**Planning Act 2008 – Section 88 and the Infrastructure Planning (Examination Procedure) Rules 2010 – Deadline 10: Comments on Deadline 8 Submission - 9.110 Sizewell C European Sea Bass Stock Assessment - Revision 1.0**

**Application by NNB Generation Company (SZC) Limited for an Order Granting Development Consent for the Sizewell C Project**

## Appendix A: Environment Agency comments on 9.110 European Bass Stock Assessment - Revision 1.0

Figure 3. ICES stock area for sea bass showing spawning and nursery areas relative to Sizewell C (SZC) and Hinkley Point C (HPC).

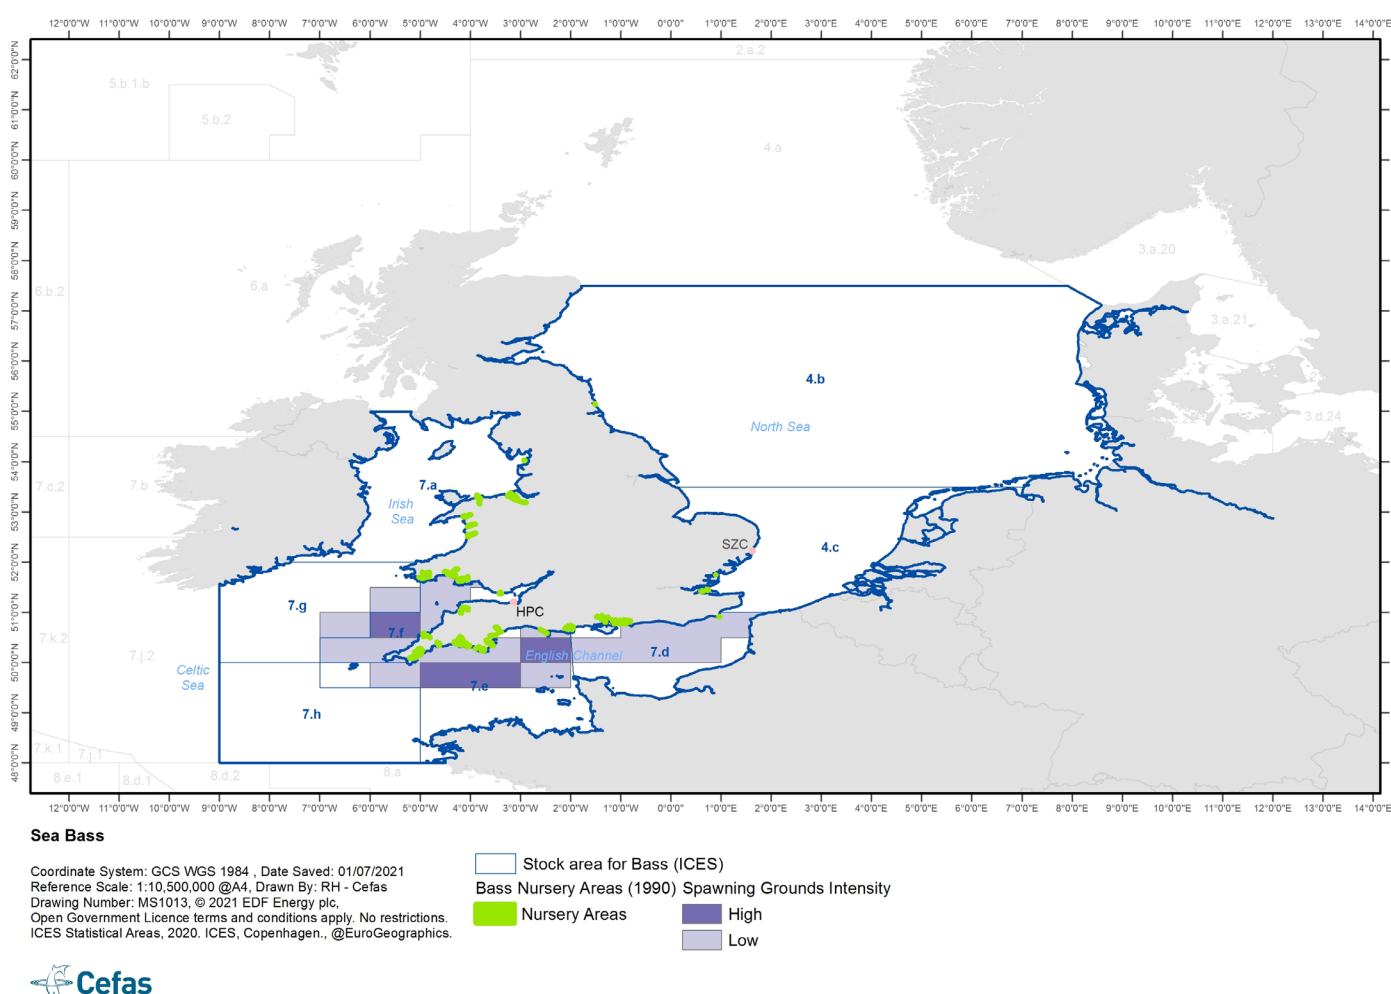
Document Title	Paragraph number	Issue	Comment	Suggested solution
SZC_Bk9_9.110_Sizewell_C_European_Sea_Bass_Stock_Assessment	Figure 3	The stock assessment method does not address the EA concerns over the area of assessment. Using the ICES stock assessment areas assumes an area for European seabass of 608,983 km <sup>2</sup> .	Recent papers, including Stamp et al (2021), Identifying juvenile and sub-adult movements to inform recovery strategies for a high value fishery - European bass ( <i>Dicentrarchus labrax</i> ) which shows high site fidelity of juvenile and sub-adult European seabass.	Need to provide an assessment at an appropriate local scale for the European seabass that recognises the latest research into site fidelity and seabass movement and the likelihood of local populations that could be impacted by SZC.
SZC_Bk9_9.110_Sizewell_C_European_Sea_Bass_Stock_Assessment	Section 1.2.2 and Figure 1	Years of stock assessment versus health of seabass fishery.	The stock assessment has included years from 1985-2020 however it has not taken into account the most recent stock assessment and fishery advice which shows that the stock is currently below safe limits.	The analysis needs to include the current state of the stock in the assessment and the assumption of a 50 year lifetime of the plant acting on a stock that is currently at the lowest safe limits
